**TOWN OF MONUMENT - WATERLINE AND STORAGE TANK
SITE DEVELOPMENT PLANS
LOT 6, FOREST VIEW ESTATES FILING NO. 4**

**2.0M GALLON TANK
GRADING AND EROSION CONTROL PLAN**

PCD FILE NO. PDR-21-030

GRADING AND EROSION  
CONTROL PLAN  
SCALE: 1"= 20'

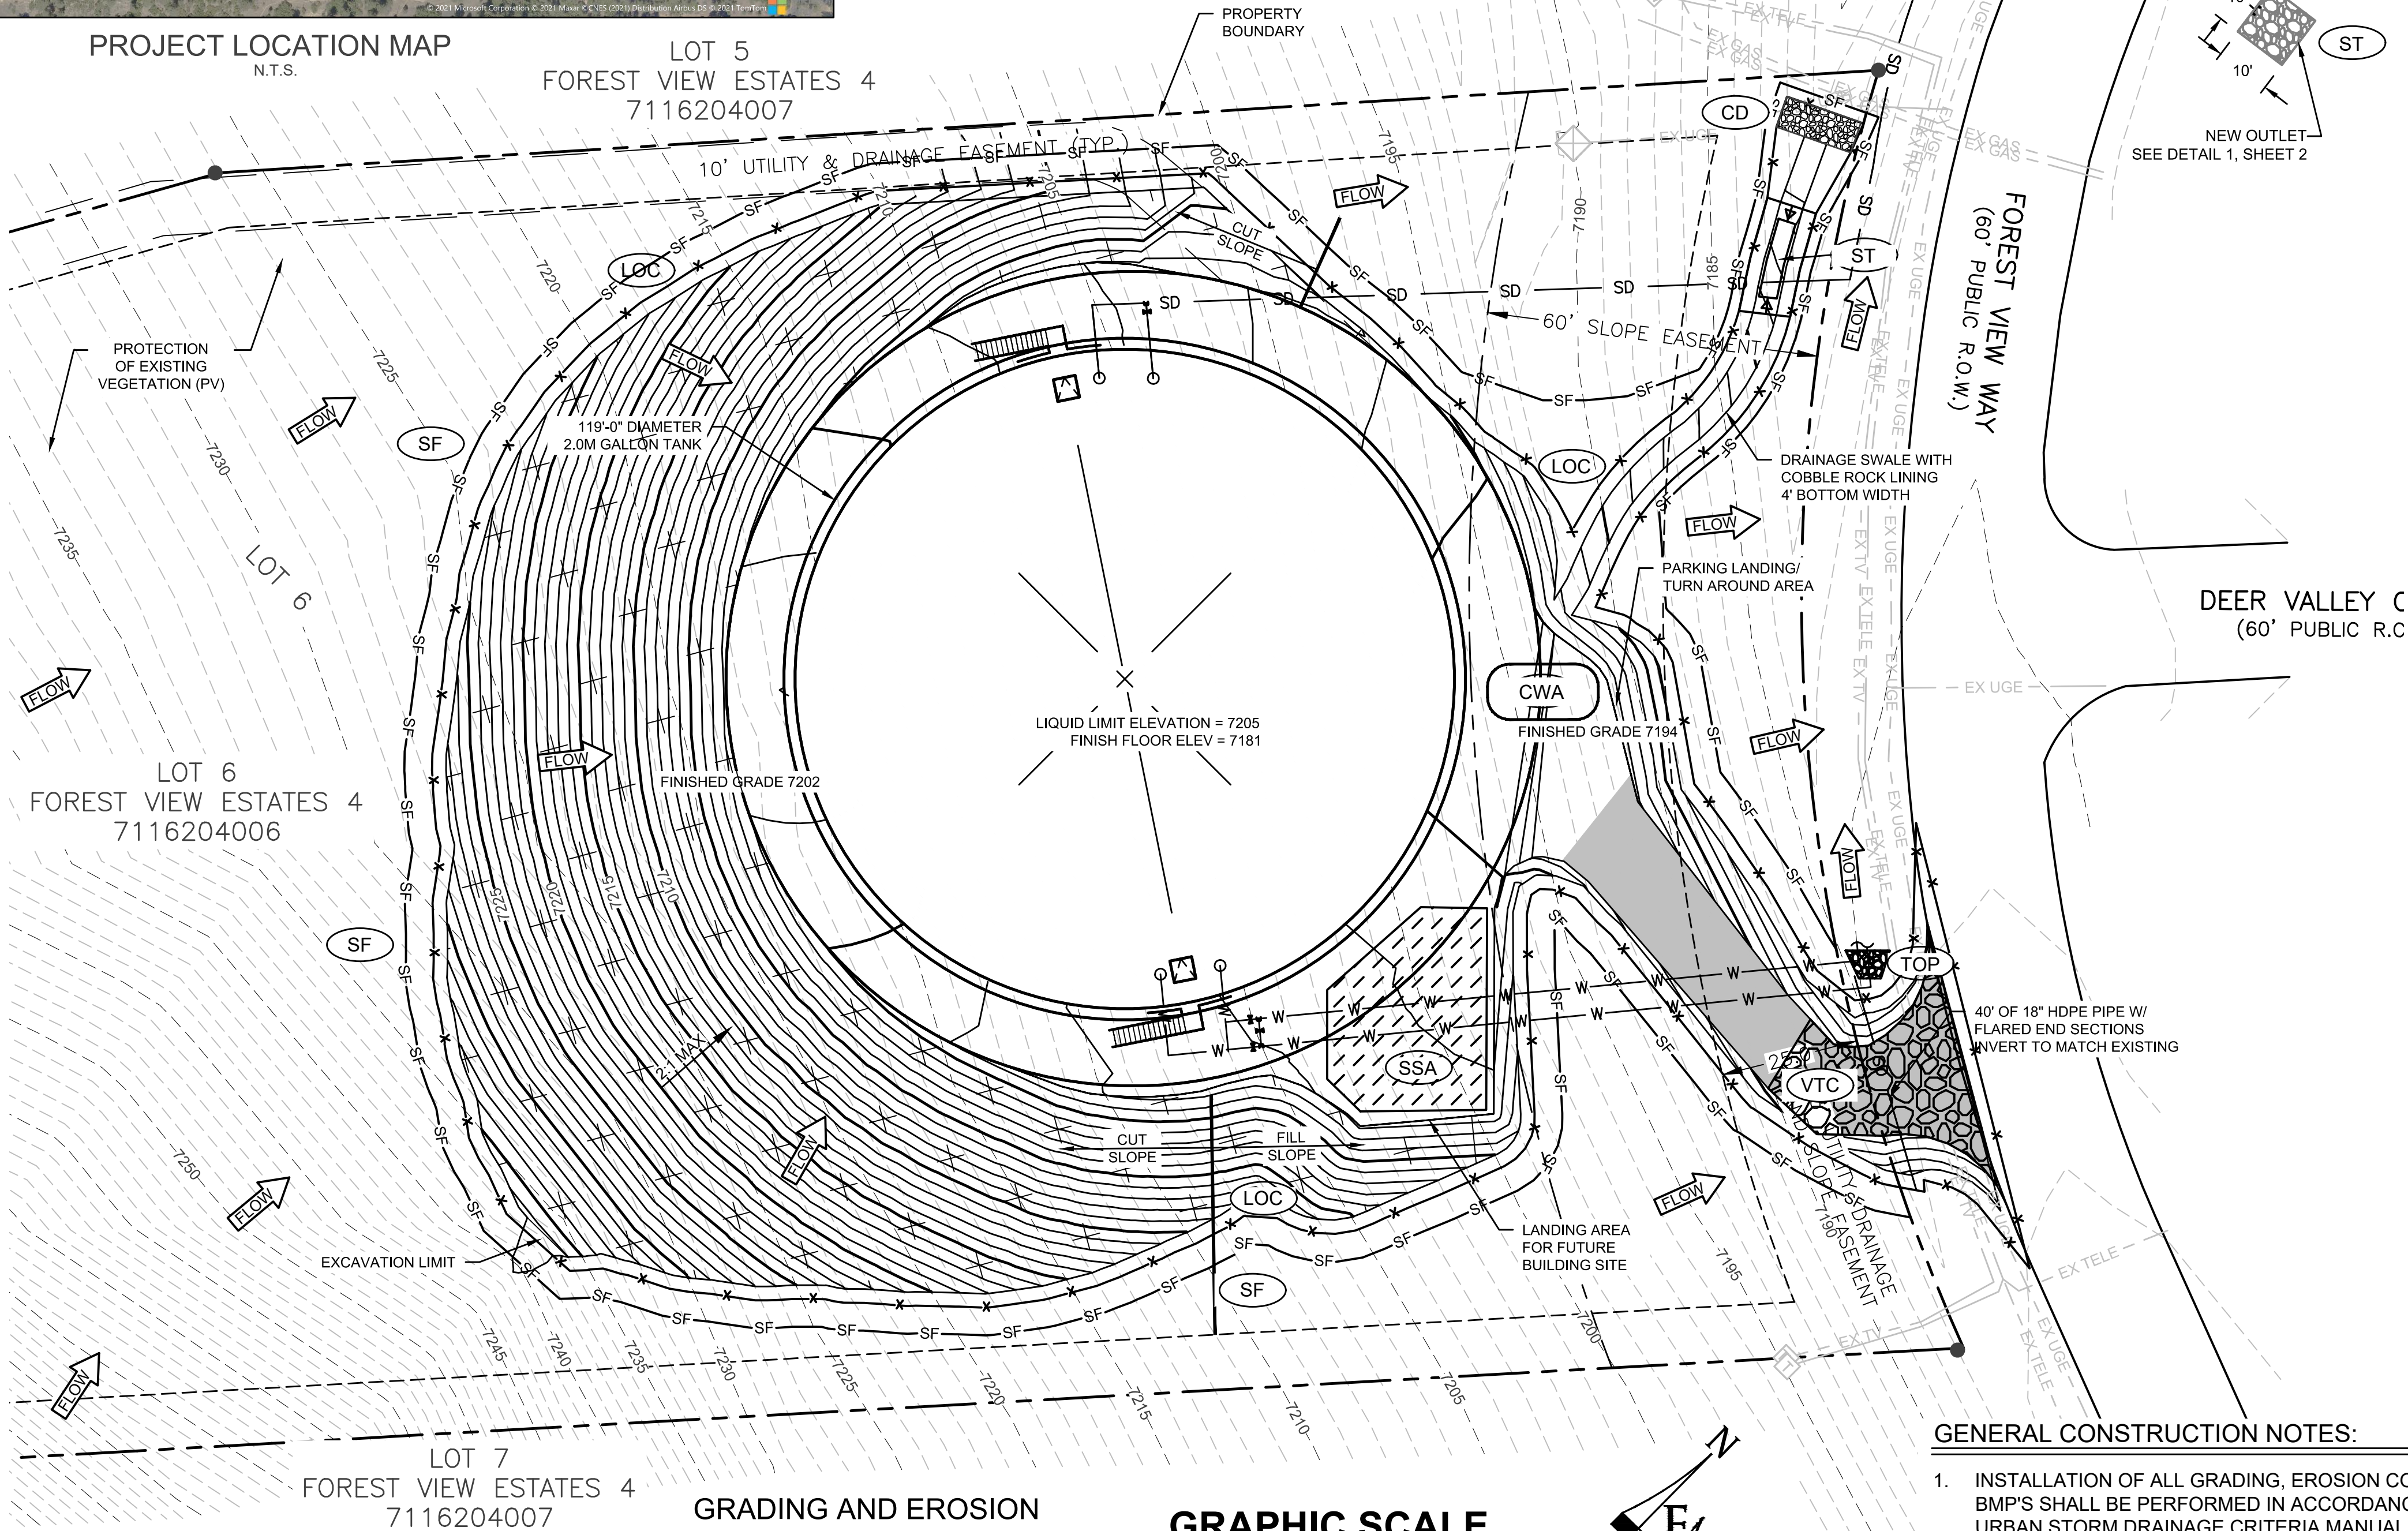
Please provide a copy of the grading notes that are in the site development plan.

HDPE is not allowed for driveway culverts. Revise to use RCP or CMP.
